Application 2026/91657 – Clarification required regarding external-wall return at Plot 23

I wish to raise a further concern regarding the external-wall junction between the kitchen projection and dining-room elevation at Plot 23.

Ground Floor (1:100)

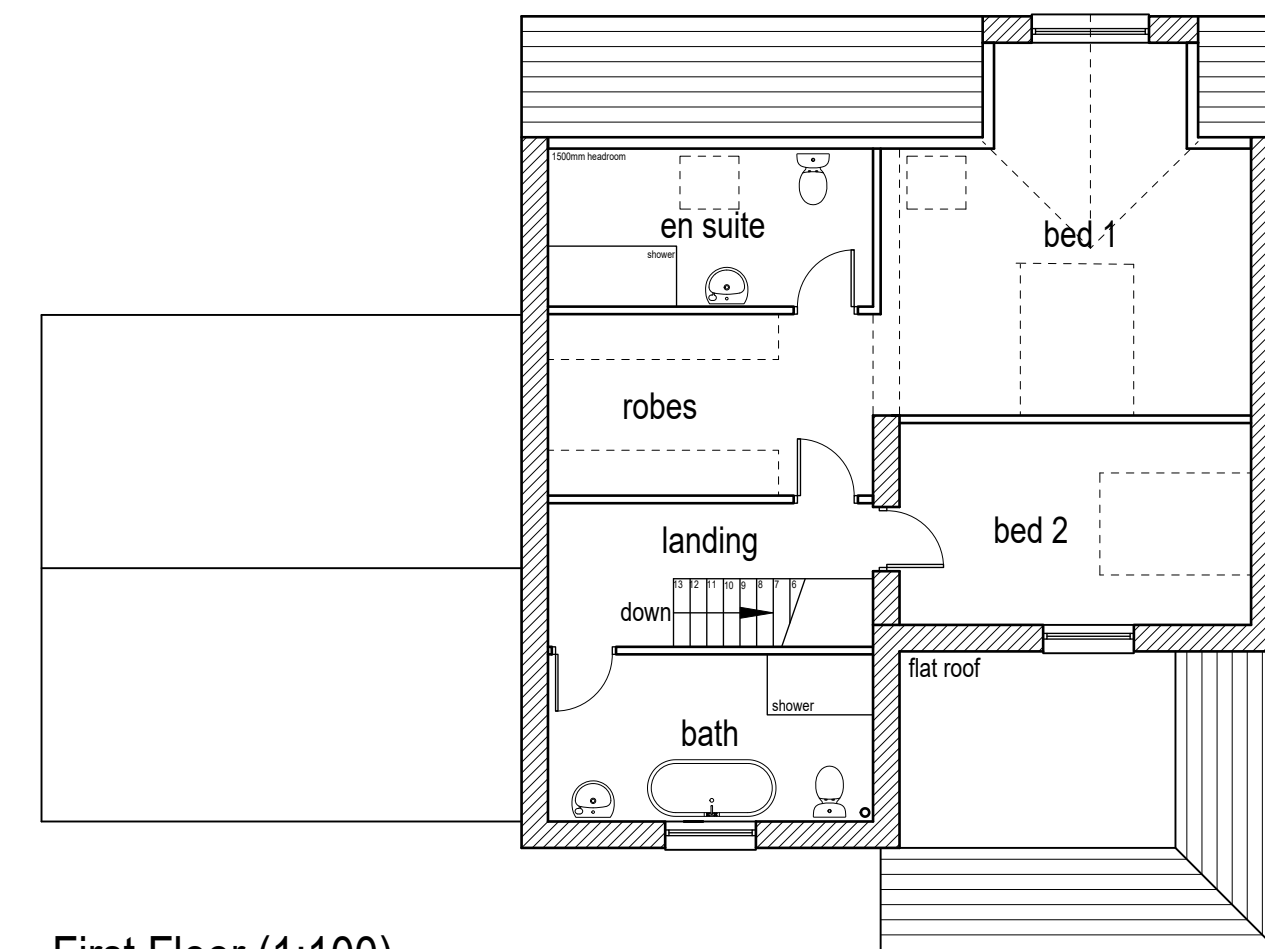
The submitted floor plan appears to show a solid external wall turning through approximately 90 degrees at this location. The attached plan identifies the relevant junction with a red arrow and shows, with a green arrow, the approximate direction from which the accompanying photograph was taken.

The construction currently visible does not readily correspond with the masonry return represented on the plan. The facing stonework terminates in a notably neat, straight vertical edge. The adjoining blockwork does not presently appear to form the projecting return shown on the drawing, nor is there any obvious continuation of the facing stone around that corner.

This raises a legitimate possibility that a separate framed, clad or otherwise non-masonry element may be intended at the kitchen/dining junction, or that the completed external form may differ from the submitted drawing.

- the precise wall line and dimensions;
- the proposed masonry return;
- how the facing stone is to continue around the corner;
- the relationship between the facing stone, cavity and blockwork;
- any frame, cladding, infill panel or separate construction element intended at this location;
- the final external materials and appearance; and
- confirmation that the completed built form will accord with the submitted plans and elevations.
